CITY OF ALBUQUERQUE

RE: 10800 Gibson SE (SSTP)
Grading and Drainage Plan

Engineer's Stamp Date: 7/18/17 Hydrology File: M21D007A1

C-101

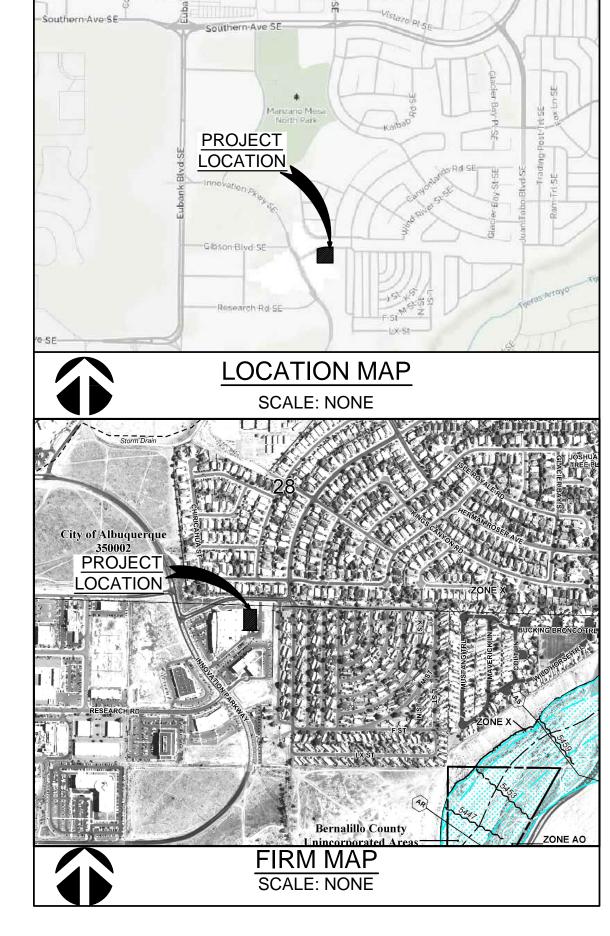
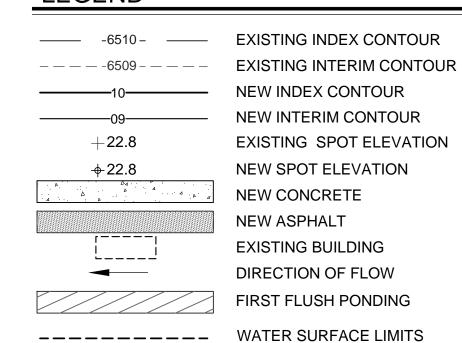
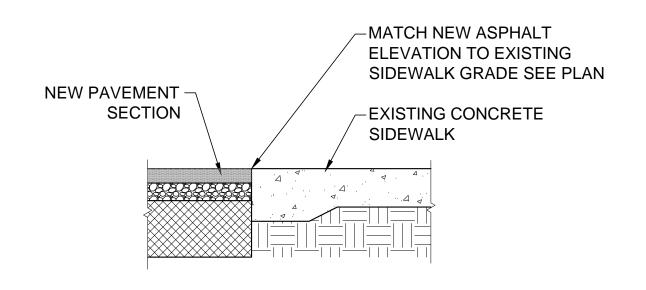
1. First flush volume needs to be determined from: (0.44"-0.10") x impervious area. The determination from 0.43" x impervious area over-estimates the required ponding volume.

2. What is the 100yr water surface elevation for the pond and where does it overflow?

- a. An outfall capable of passing the 100-yr peak inflow (roughly 2.5 cfs for this site) is recommended for ponds storing less than the 100-yr, 10 day runoff. Ideally, the outfall invert should be at least 1ft below the finished floor of the adjacent building; this may not be possible for this site. The southeast corner of the pond, near the ADA parking seems to be the only outfall that will keep flows routing away from the building.

- b. For ponds with no outfall, the 100yr, 10day water surface elevation should be determined; ideally the maximum water surface should be at least 1ft below the building finished floor. Some ponding in the parking lot is permissible for the City, but should be discussed with the client.
